Executive Summary

1. CTS Traffic and Transportation have been appointed by Mr Jonathan Finch to produce a Highways and Transport Review of the supporting information, and local Highway Authority responses, to a proposed development of homes on a site at Salesbury View, Wilpshire, Blackburn.

PROJECT / CLIENT Salsbury View, Wilshire for Persimmon Homes		PROJECT NO. NB13203	
DRAWING TITLE Proposed Site Sections		DRAWING NO. 112	
PROJECT LEADER KD	DRAWN BY KW	CHECKED BY IDP	DRAWING REVISION P8
SCALE 1200 @ A0		DATE August 2025

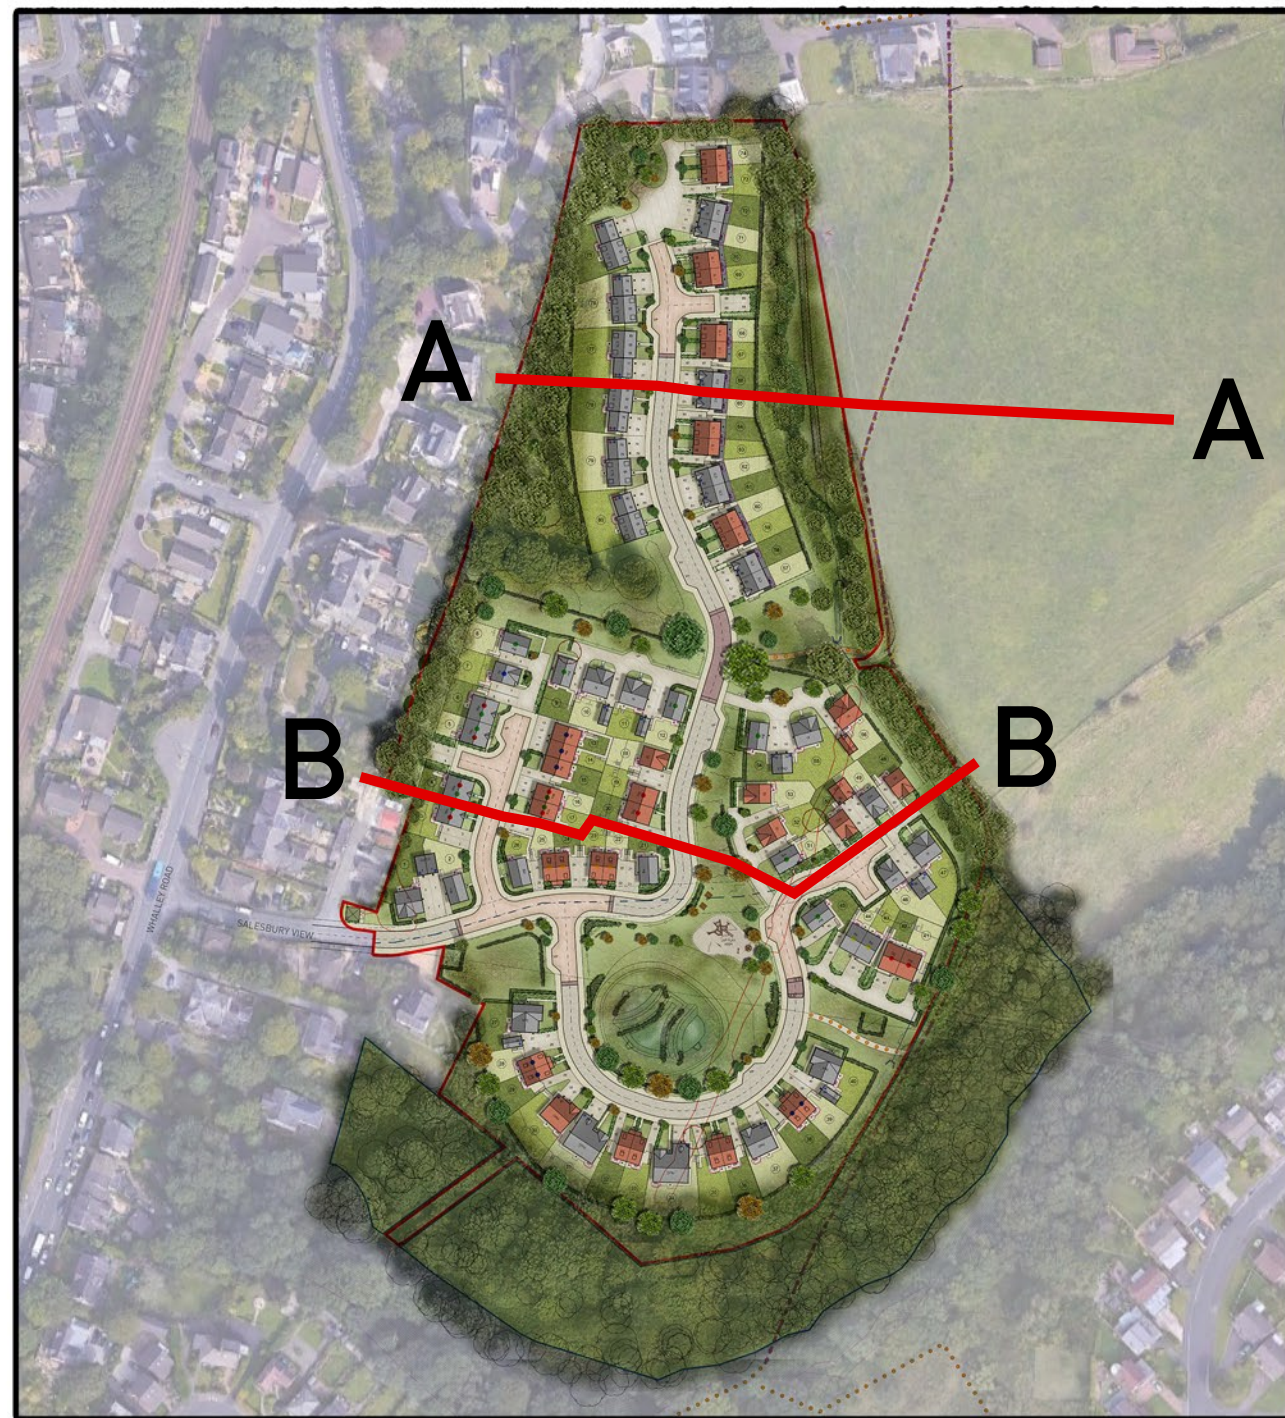
21. As part of this review such plans have been produced for the second and current (third) applications. In the case of the second application, there would be around 230m of carriageway following on from the existing 1 in 8 gradient of Salesbury View before there is a section flatter than 1 in 20.

22. In the case of the current application, there would be a section at the start of the access road following on from the end of the existing 1 in 8 gradient of the existing Salesbury View of around 20m at 1 in 20. This would then be followed by a continuous length of around 175m at greater than 1 in 20, with long lengths at 1 in 12.

23. In both cases in addition to the far longer than 2m lengths of the sections at 1 in 12, there are long footways with gradients greater than 1 in 12 which is simply not in accordance with Inclusive Mobility standards.

45. Many of the consultees would not have been aware of the gradients of the access road and the lengths over which such gradients would exist. It is therefore recommended that the applicant be required to provide a similar plan to that which has been prepared for this review, or confirm that the objector's plan is accurate.

Drawing file: planx_downloads / 25_0801_Speed_Survey_26Aug26.pdf

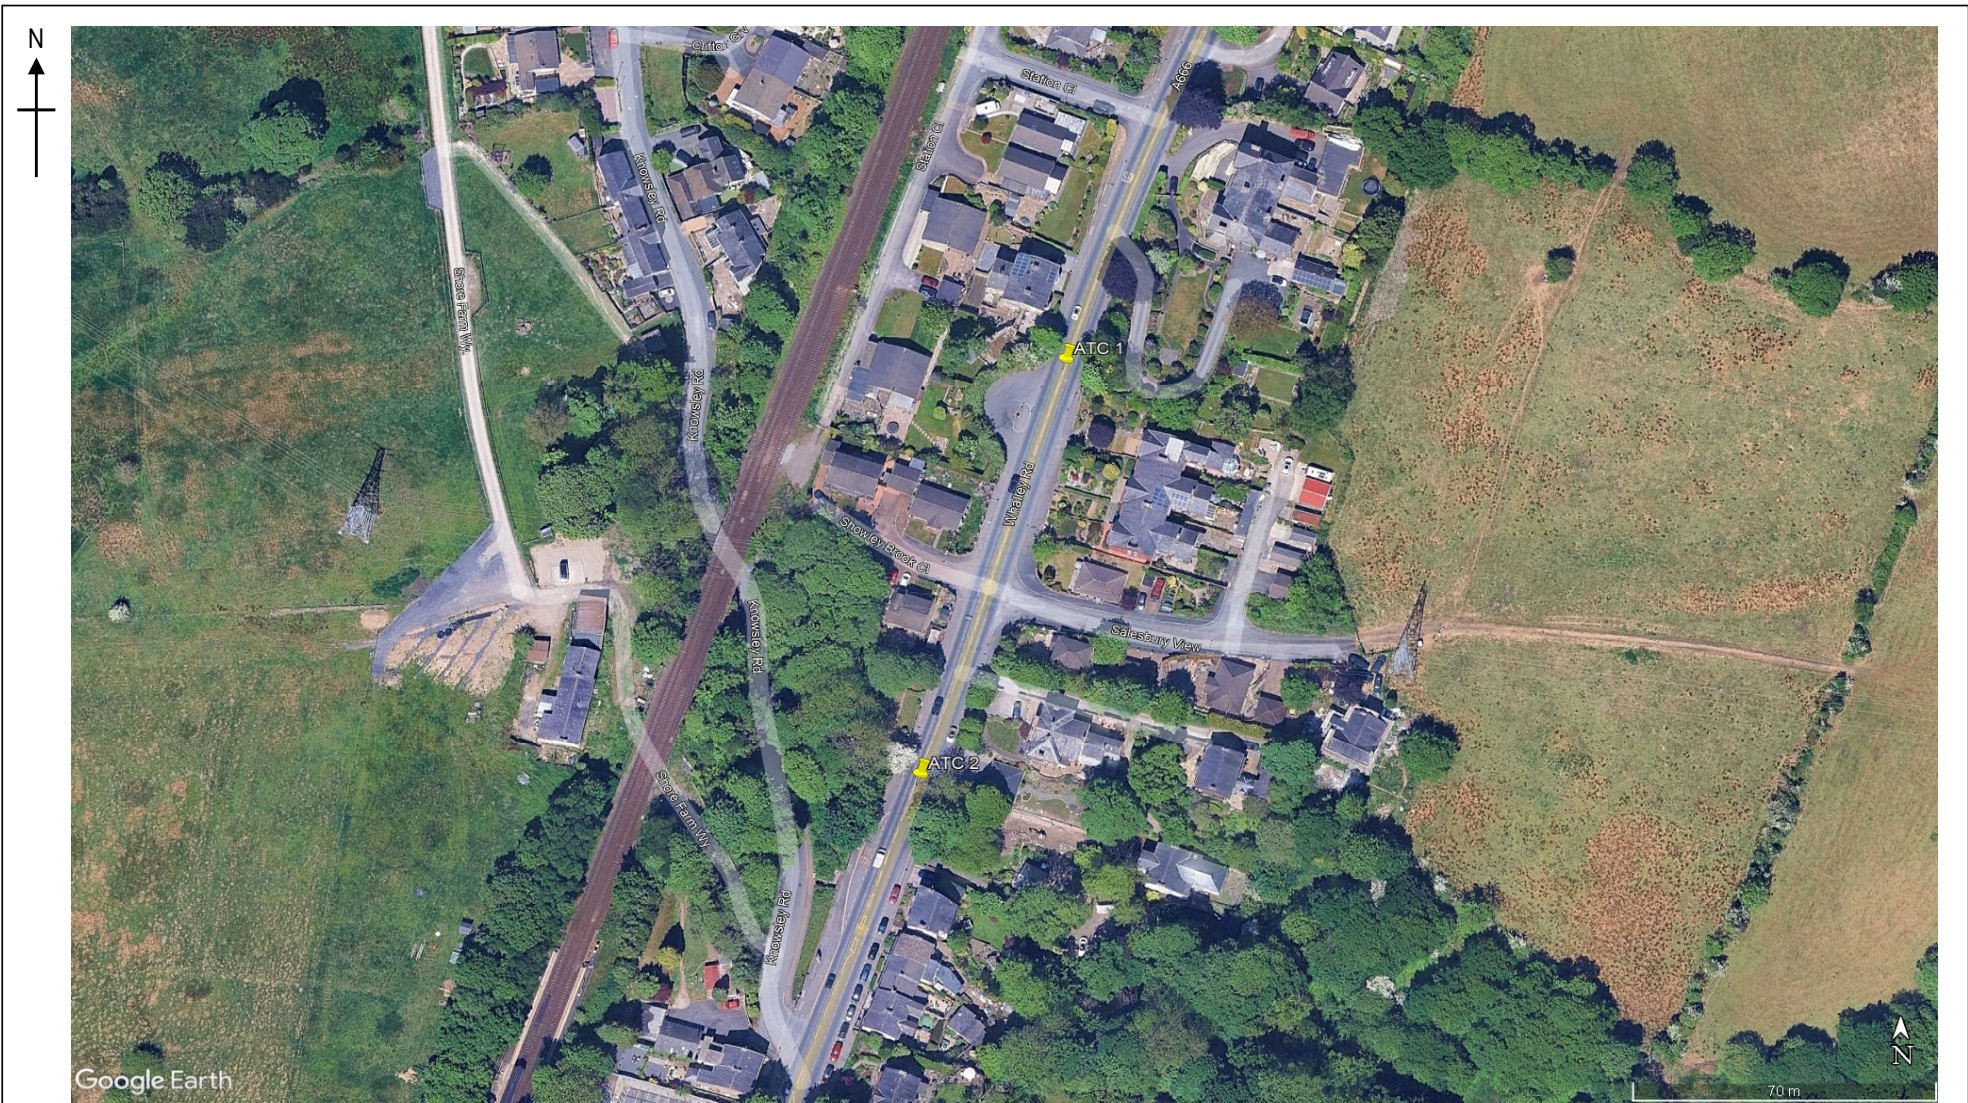
28. This relates to the safety of the Whalley Road / Salesbury View junction.
29. In the first response to the first application the Highway Authority states that the speed survey used to determine the appropriate visibility splays at this junction was not fit for purpose, listing the reasons, and requiring a survey that was fit for purpose before the application could be considered.

31. In addition to the list of factors given as to why the survey was unacceptable, it is stated that the survey was undertaken during the peak periods. If this is in fact true, then the DfT standards particularly direct that speed surveys must not be undertaken in such periods.

32. The survey is now many years out of date and for a 2025 scheme a new survey should have been undertaken in any event.
33. The survey showed average speeds on Whalley Road just over 30mph. This seems very low. Little confidence can be applied to the 85th %ile speeds quoted for the visibility splays.

34. It may be that the appropriate visibility splays can be provided. It is simply impossible to say. A new survey fully in accordance with the correct standards and methodology should be undertaken.

53. The survey, in any event, is long out of date. A new survey, carried out to the appropriate methodology is strongly recommended to determine if the junction will have adequate visibility.
